Comments in response to the Applicant's response to Relevant Representations
5th October 2021
Brown & Co on behalf of Honingham Aktieselskab

Reference: RR-023.1

SECTION 1

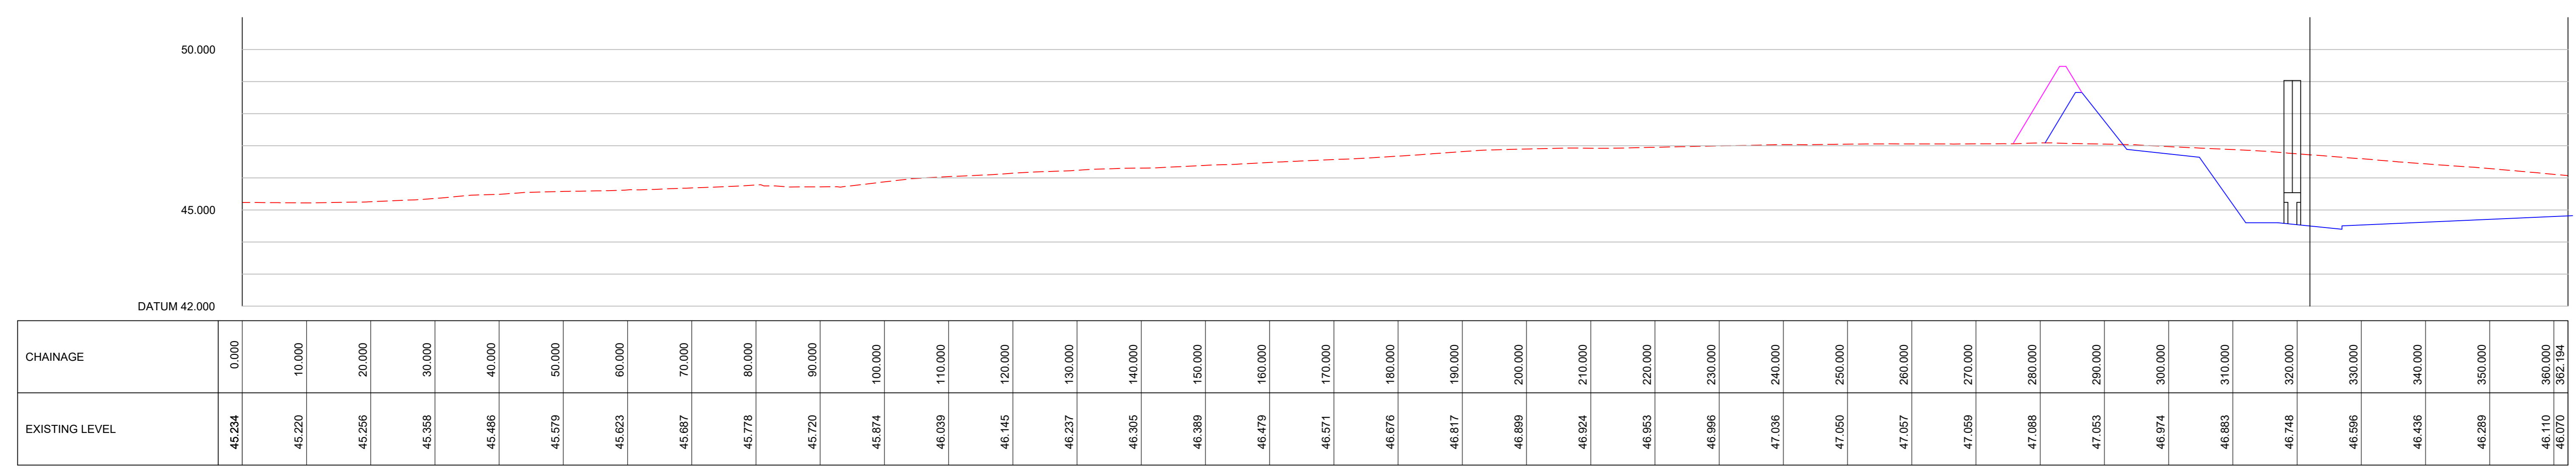
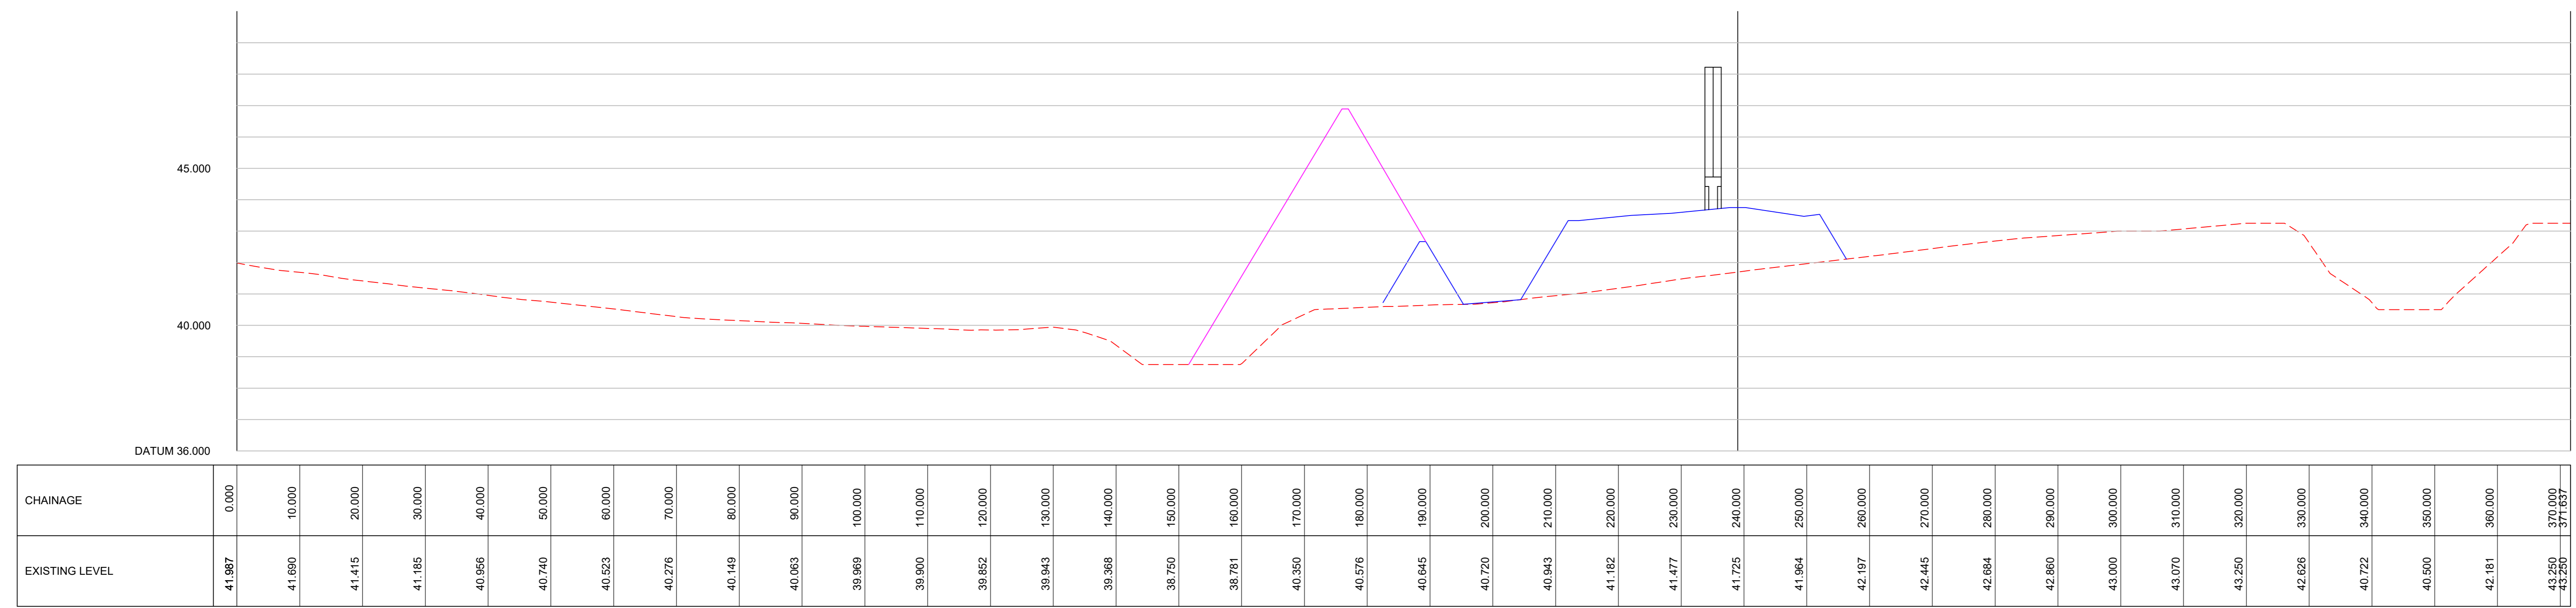
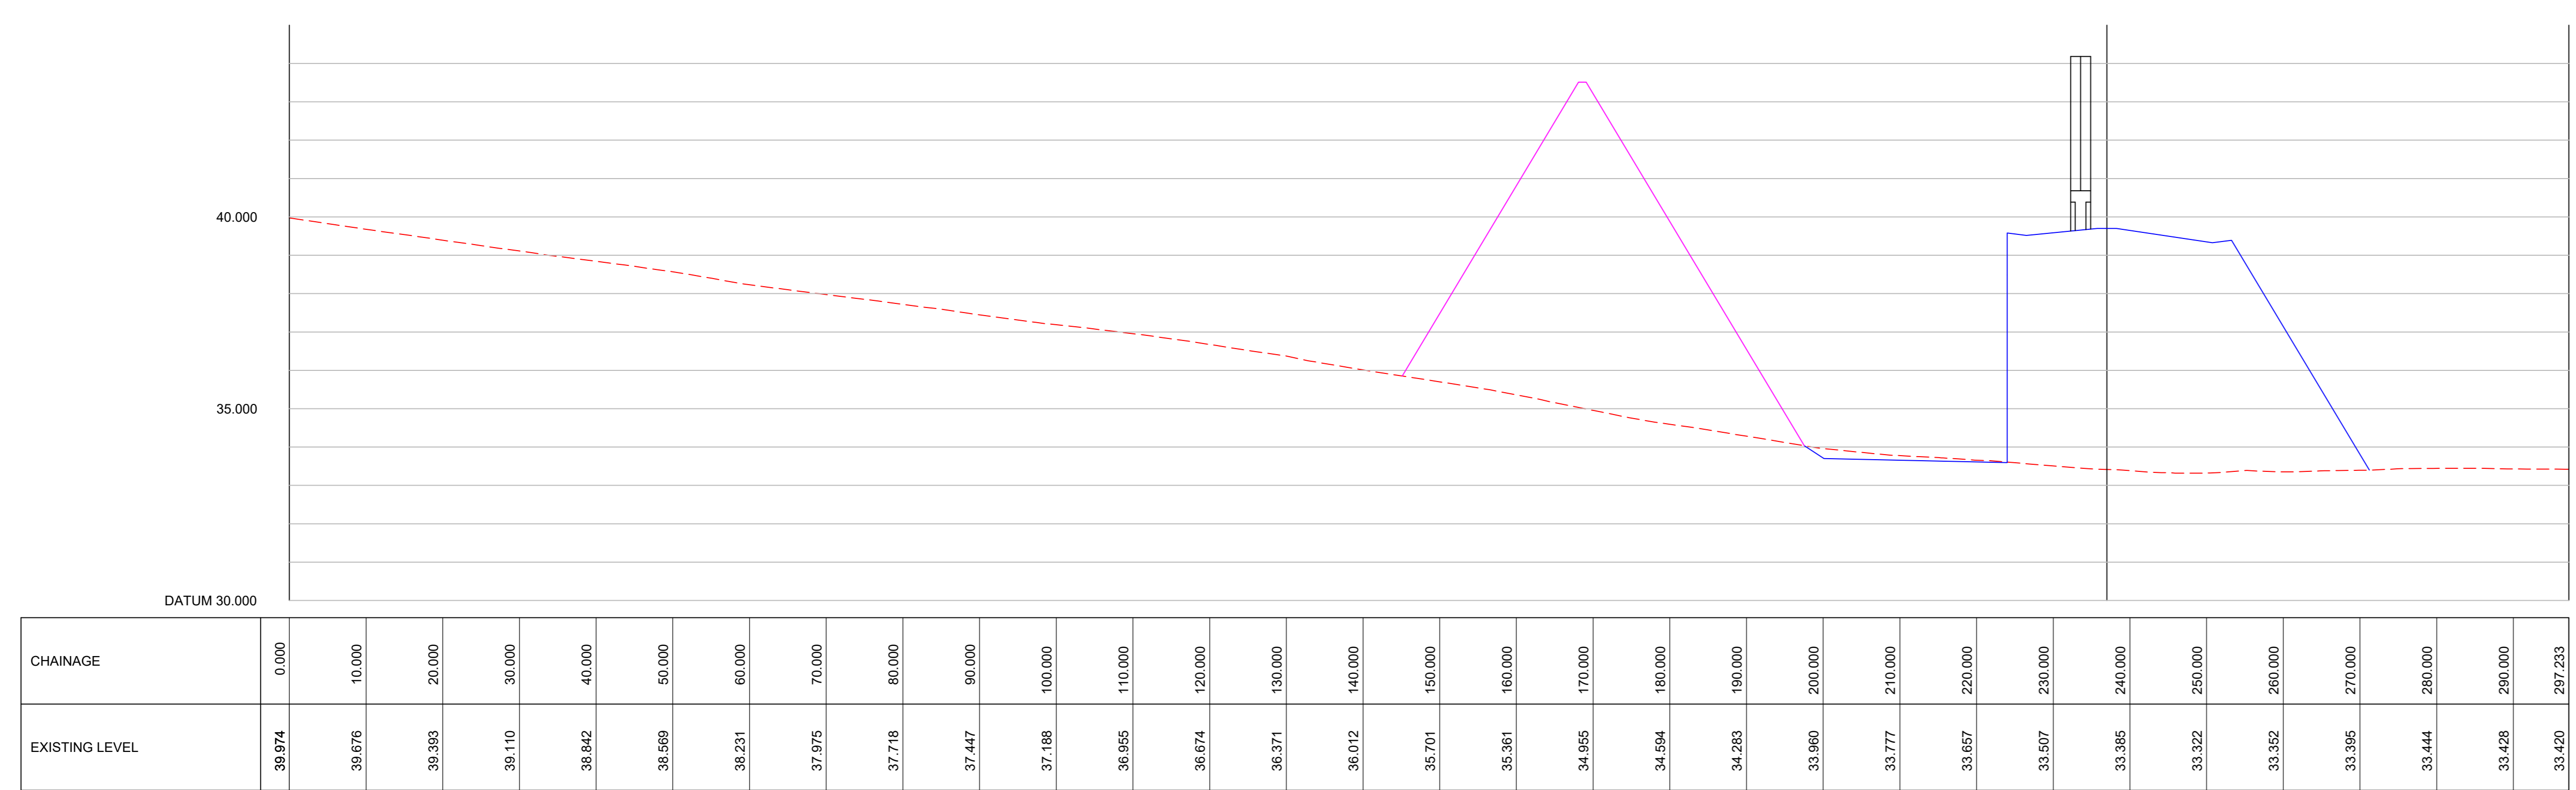
Notwithstanding the applicant's comments about chainage 5 + 650 metres to 6 + 100 metres, there are large stretches where the impact of the road will be significant, and the bank will neither mitigate the works and the use of them visually, nor assist with noise attenuation.

- **Section 1:** The view towards the Wood Lane junction is reasonably well screened because the dumbbell roundabout is low. The main carriageway, between the dumbbell roundabouts is much higher and will be open to view.
-
- **Section 2** is taken midway between the Wood Lane junction and the Hall Farm underpass. It is clear the road will be clear to view as the road stays high and rises towards the underpass. Passing vehicles will remain visible.
-
- **Section 3:** The carriageway over the Hall Farm underpass will be very high in relation to the surrounding landscape with clear visibility and no noise mitigation. These issues are not experienced with the current road, and it isn't clear why this scheme can be projected into the location without reference to privacy and landscape protection.

We hope the examining authority will direct the Applicant that further work is required to agree increased embankment heights and the extent of the embankment near Hall Farm, to mitigate the impact of the realignment of this road.

SECTION 4

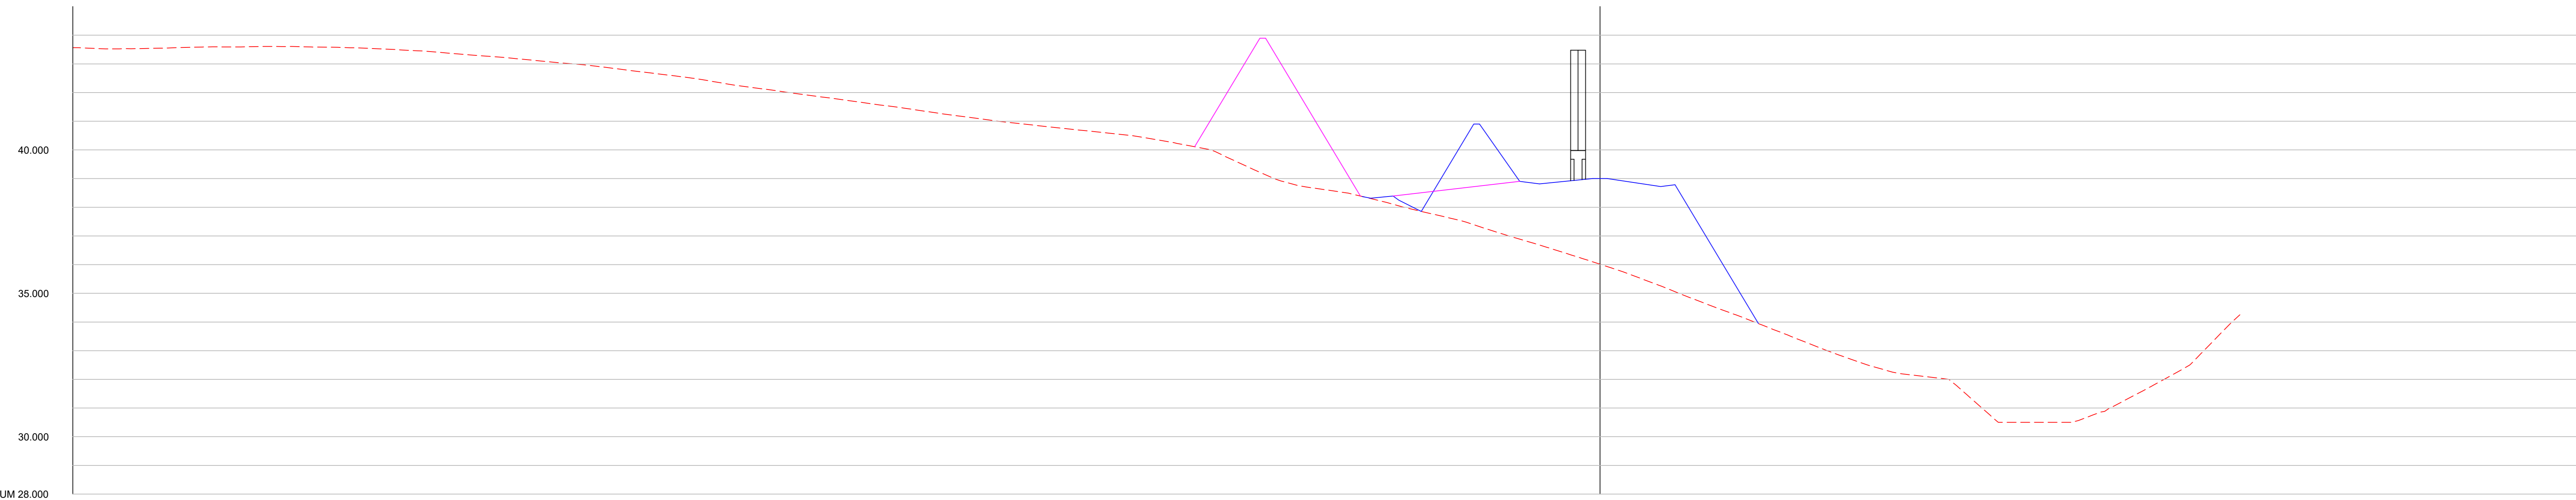
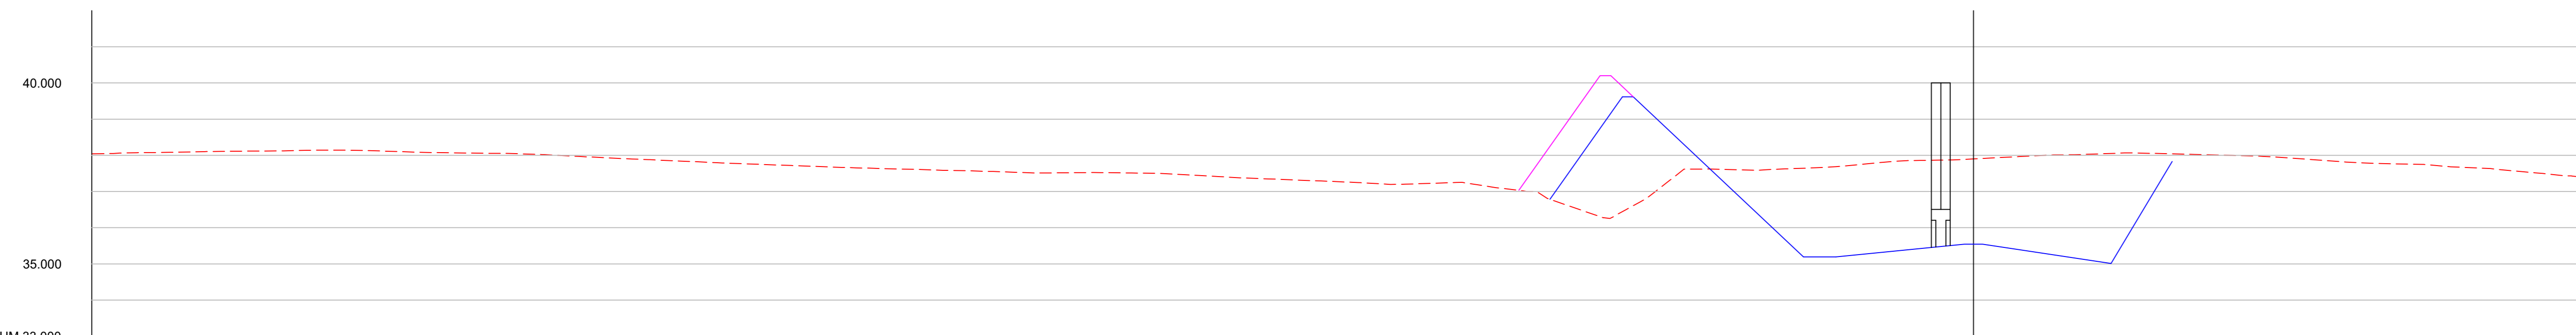
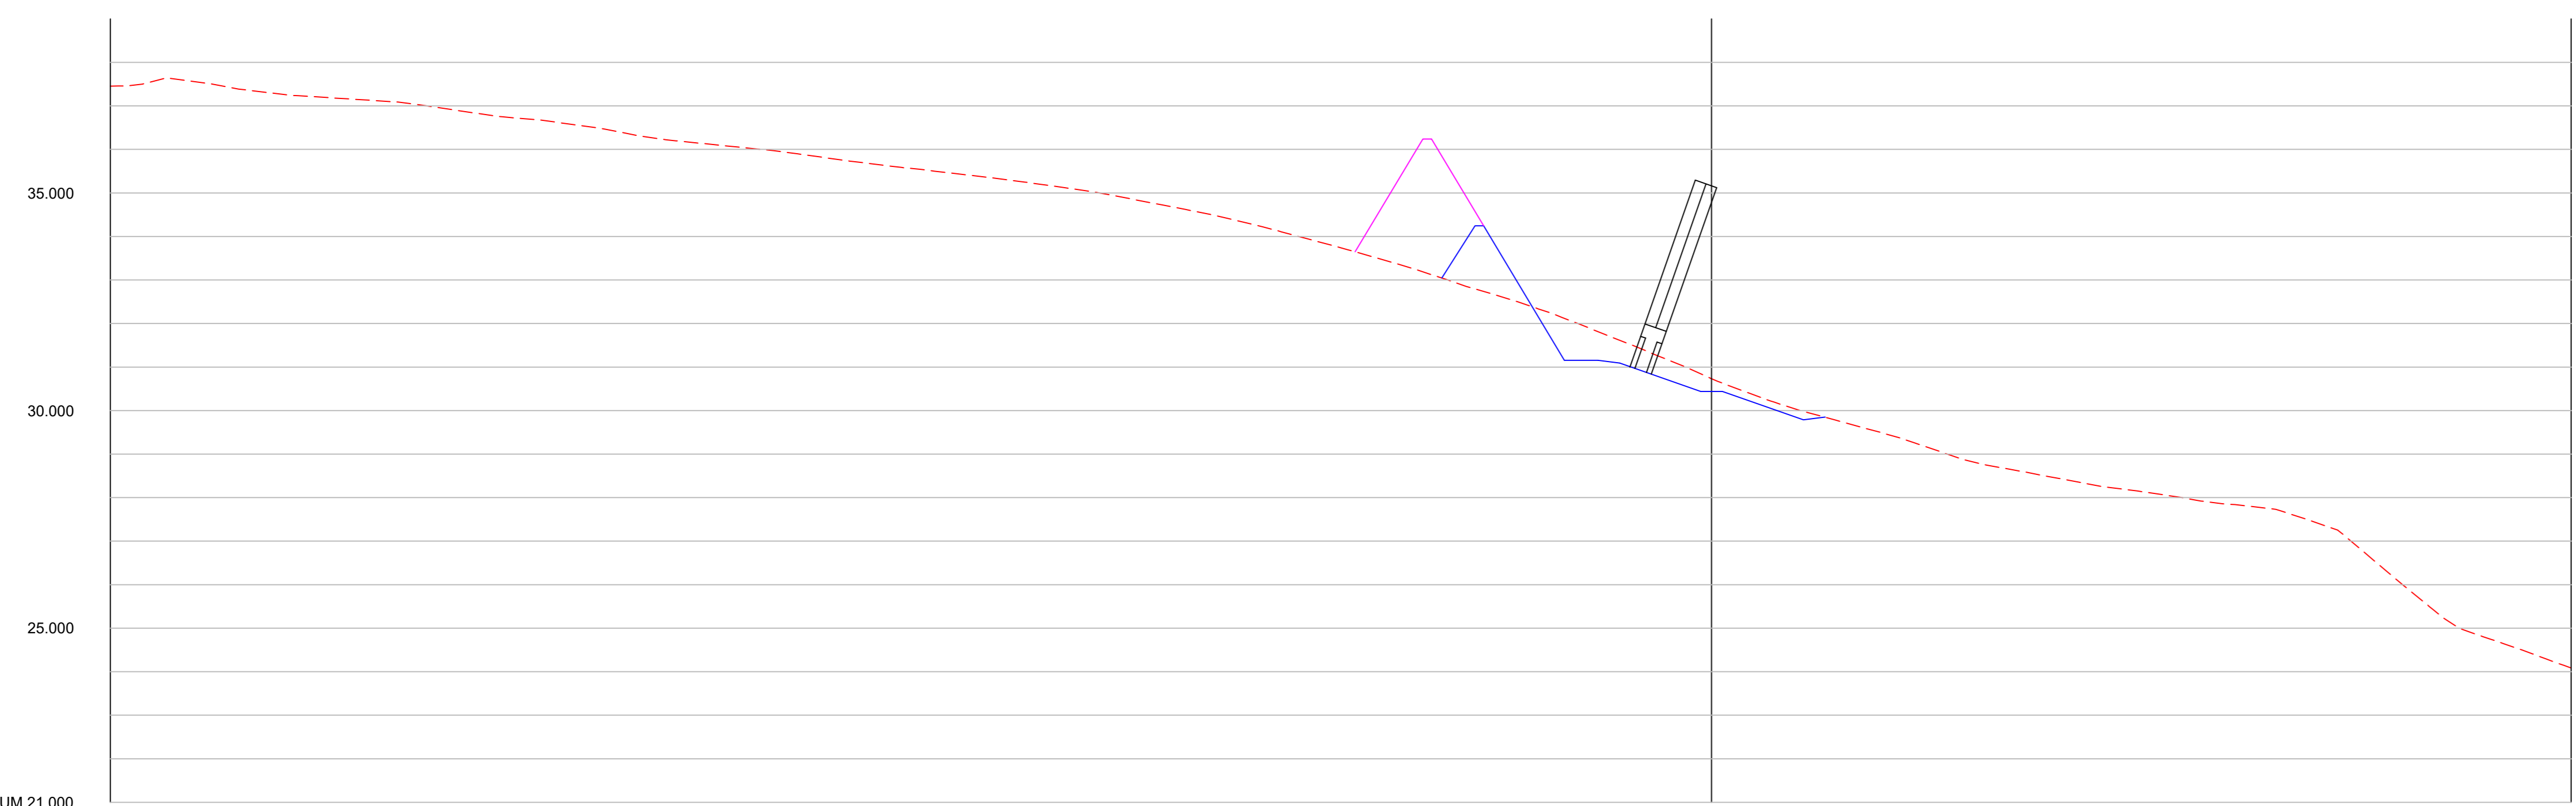
- **Section 4:** To the east of the Hall Farm underpass the road remains high and as the ground level runs down towards the road, greater protection is required. The road does then enter cutting and the impact reduces as the road approaches Hall Farm through **Section 5**.

The road is cut in around 1 metre so with the bank of 2m, although it is situated half the distance away from Hall Farm and the cottages than at present it shouldn't require much material to improve the situation.
